**RE: PPR-18-026 New Widefield PK-8 School  
First Submittal**

Please see below for response (*in blue italics*) to **PCD-Engineering Review Comments** for the above referenced project, dated July 9, 2018. Responses include input from project design engineers and consultants as follows: Drexel, Barrell & Co. for civil; William Guman & Associates for landscaping; LSC Transportation Consultants, Inc. for traffic.

C3.3

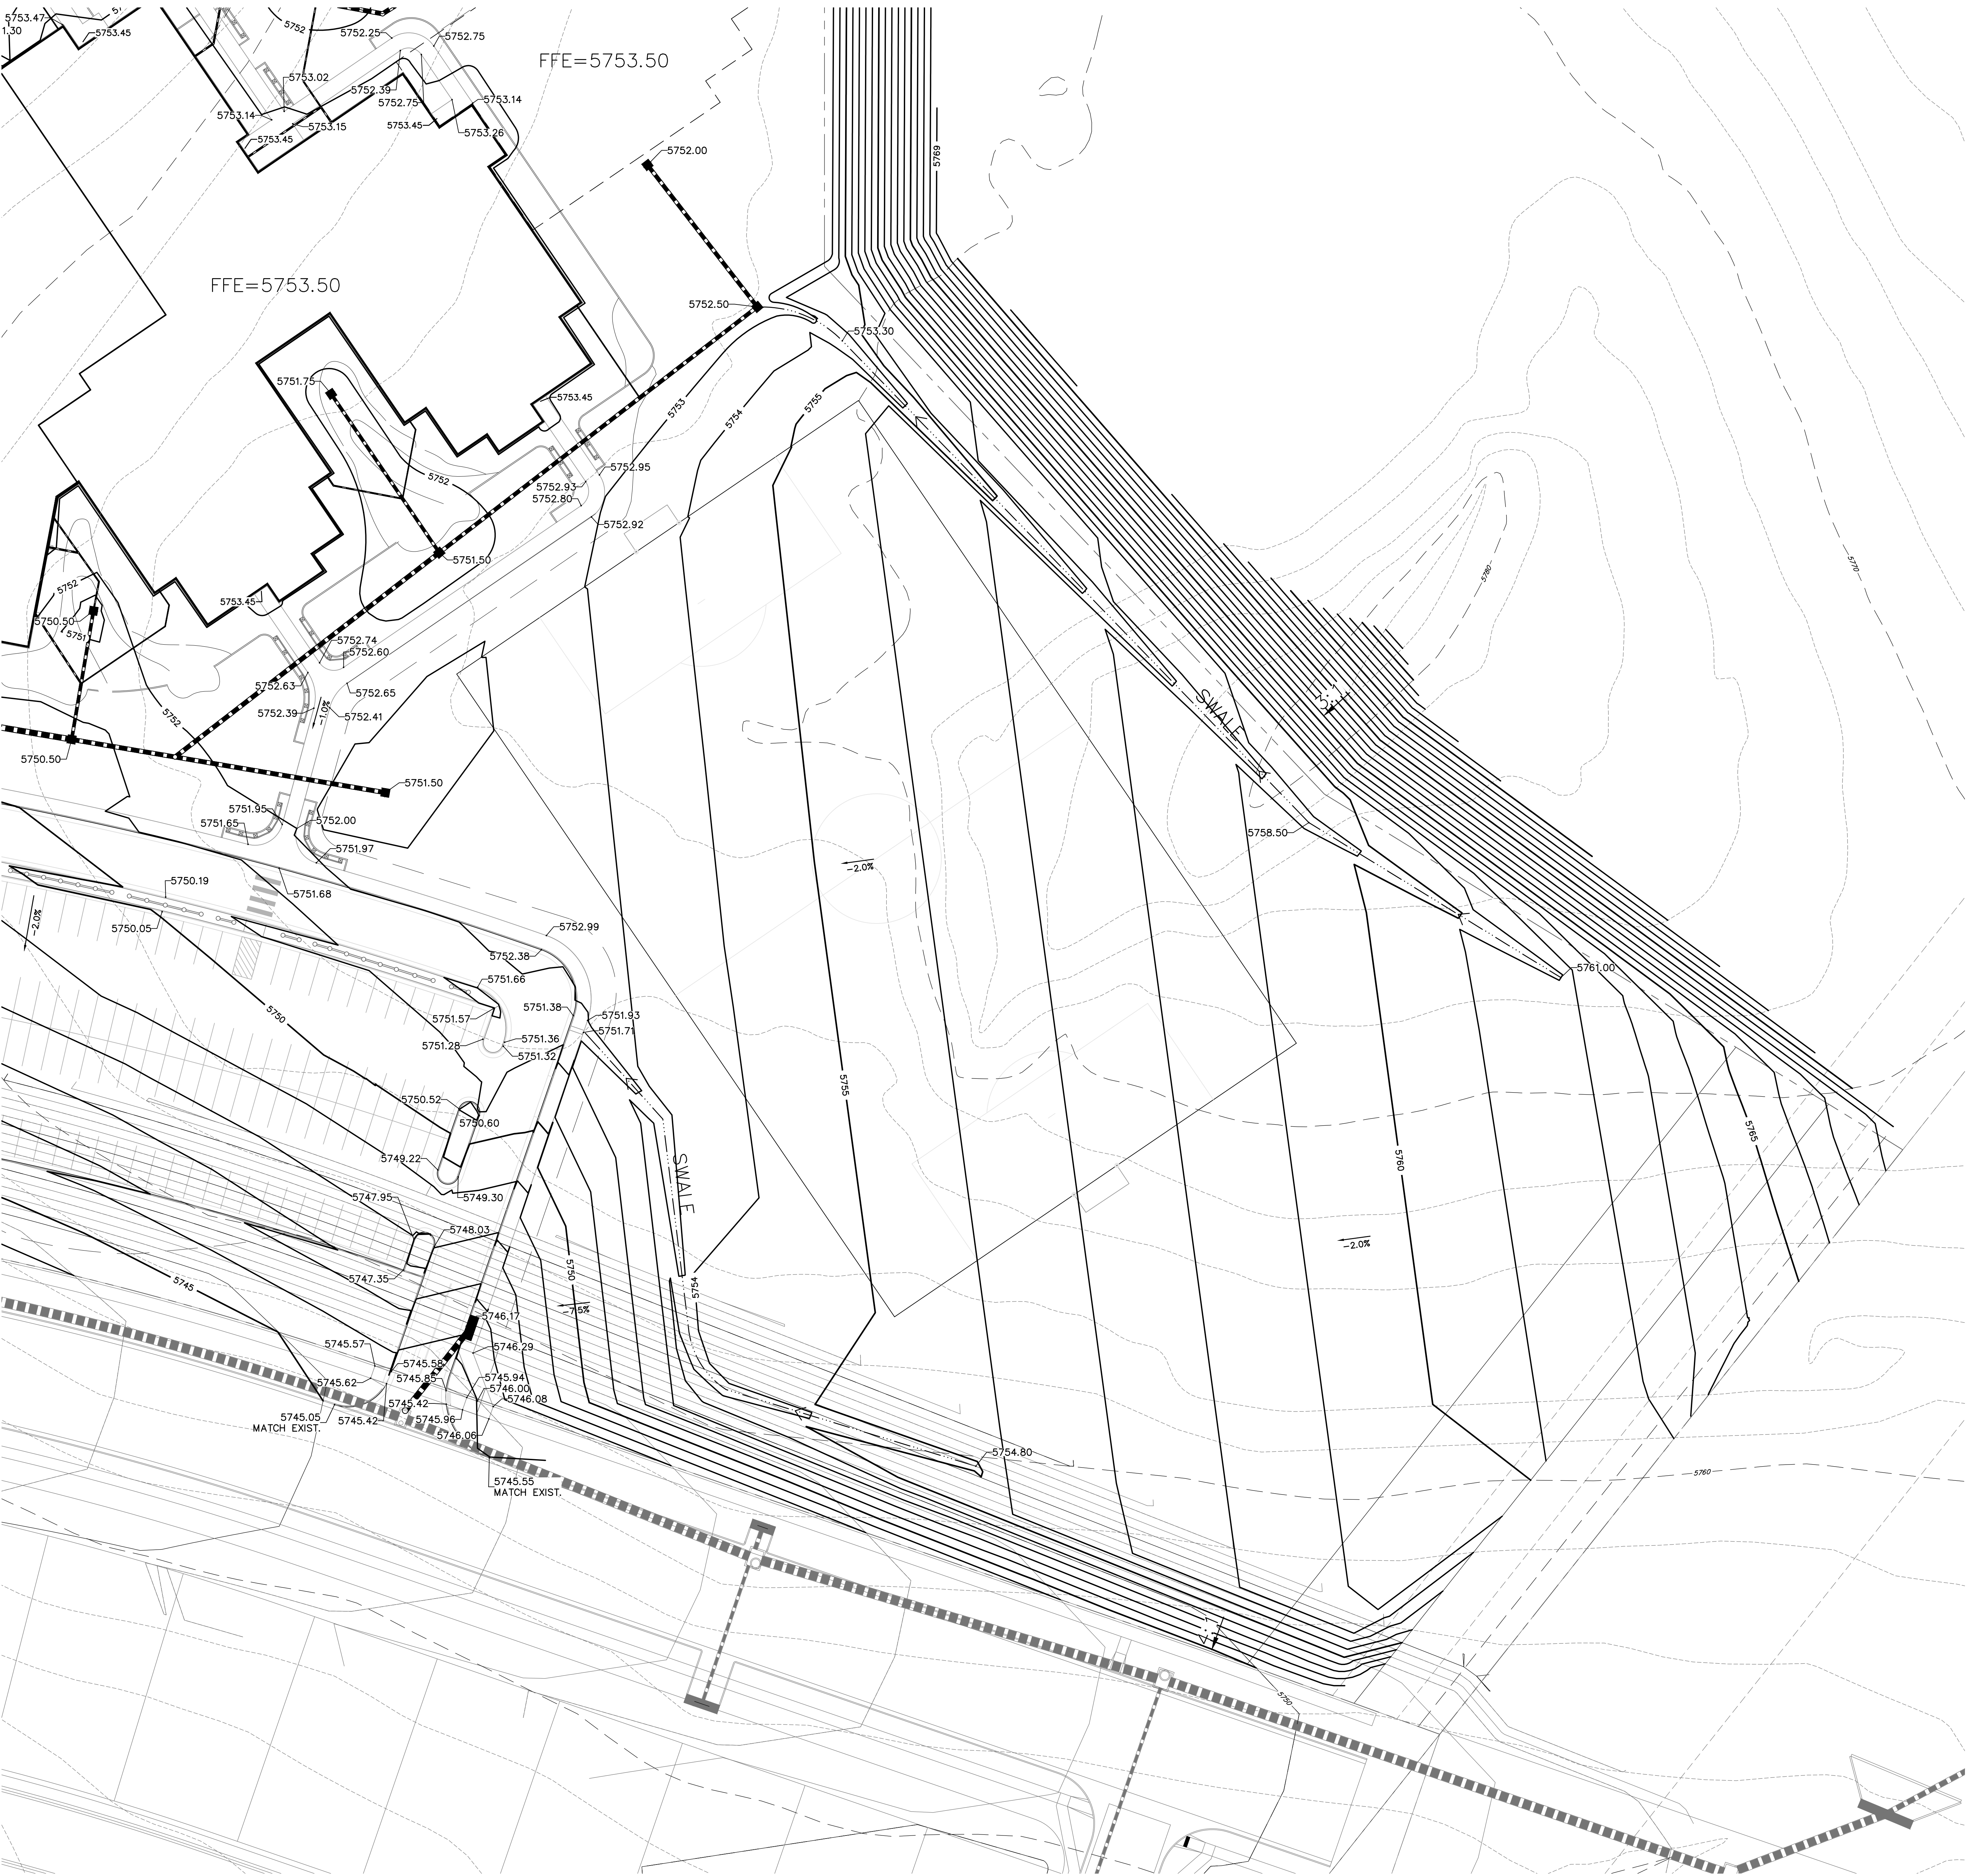
3. Provide construction details including spot elevations for all access points. **RESPONSE: See construction details on architectural SD sheets and spot elevations on civil C3-series sheets in resubmitted Site Development Plan.**

3. Provide construction details including spot elevations for all access points.  
***Construction details are on architectural sheets. Spot elevations are shown on Civil sheets C3.1-C3.4***
